# Structural Integrity

RTU Replacement, Condenser Relocation, Added Roof Insulation and Roofing Replacement  
551 Congress Street  
Portland, Maine  
Structural Integrity Job: #13-0056

**A1.01**

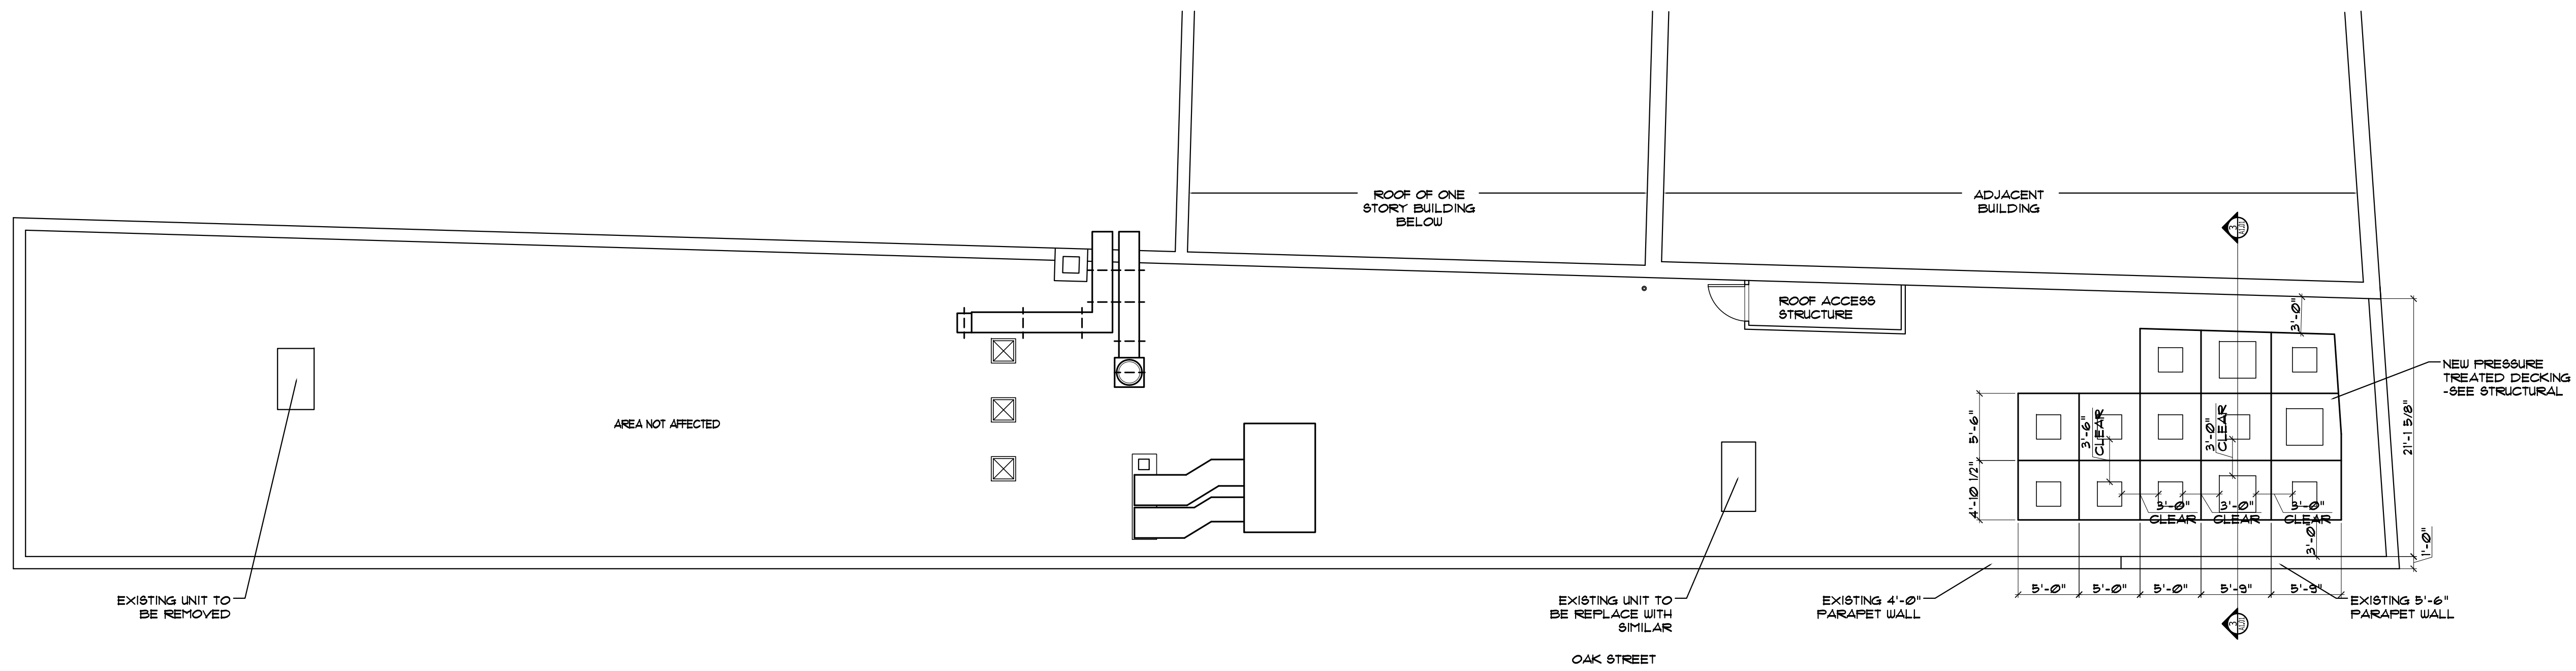
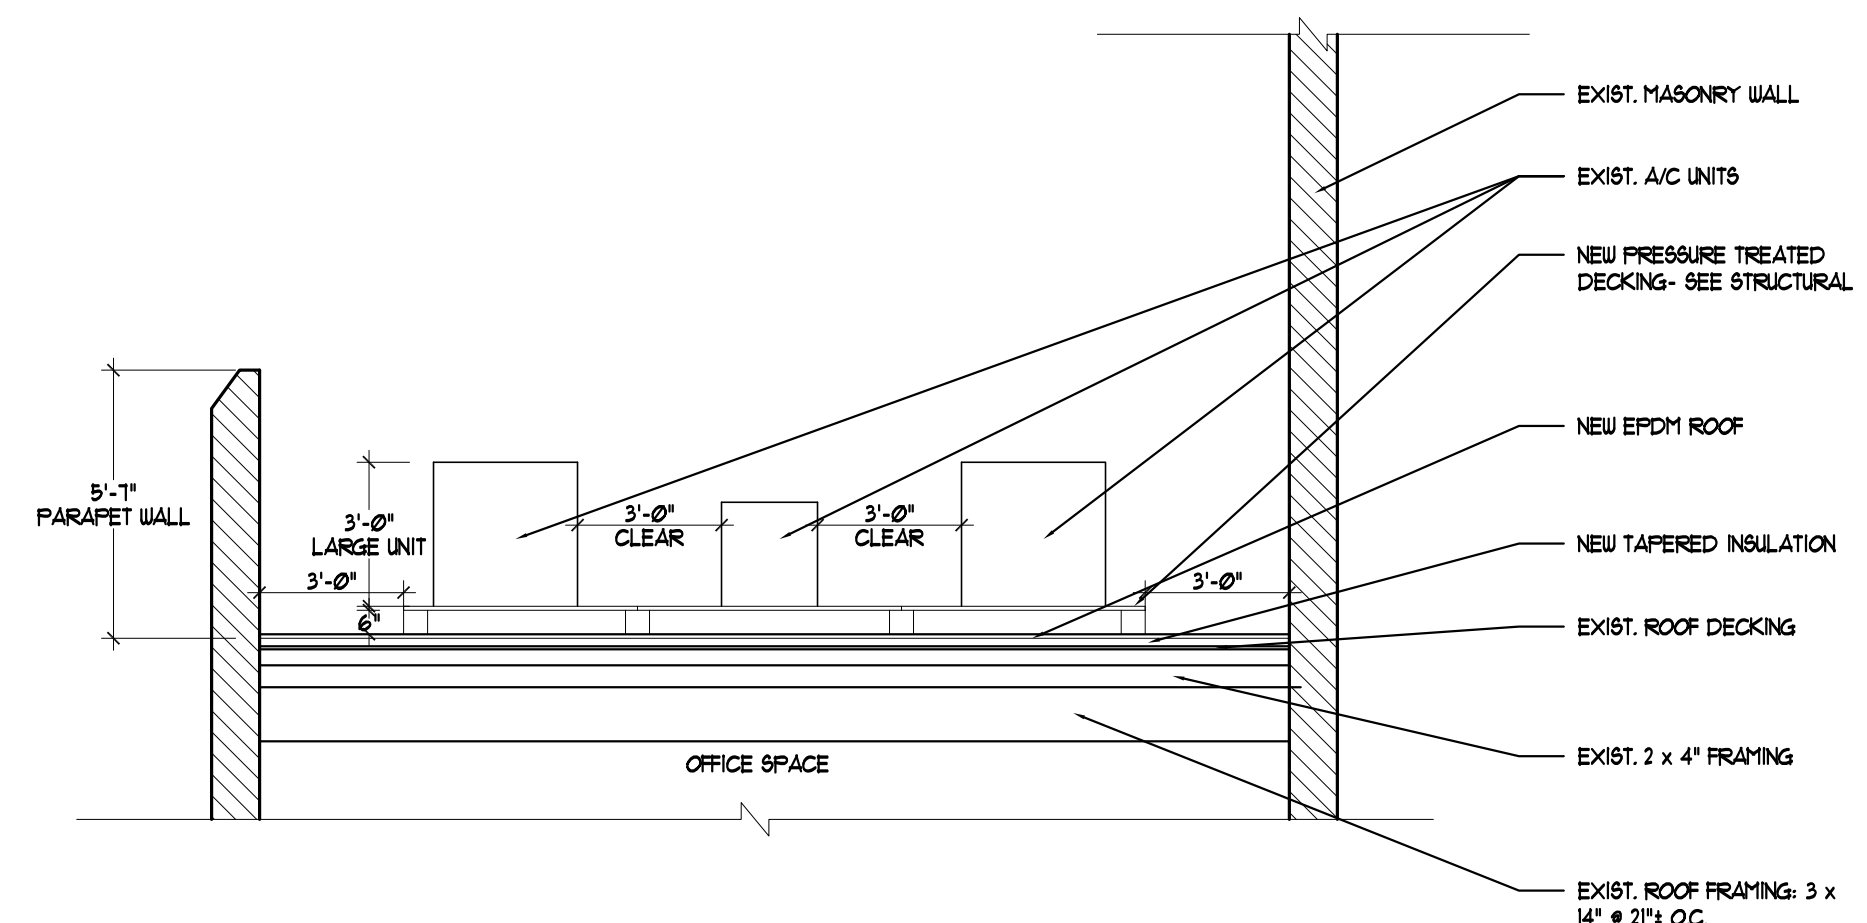
The existing roof is constructed with historic sawn rafters, 2 3/4" x 13 1/2" min. at up to 22" on center supported on a steel angle and pockets at the existing brick masonry walls. Based on my calculation I have found the existing rafters are suitable to support the code imposed loads and the roof top equipment proposed.

I have also specifically reviewed the location and installation of the Replacement RTU that is to be installed on the existing curb closest to Congress Street and found the framing supporting the RTU to be adequate.
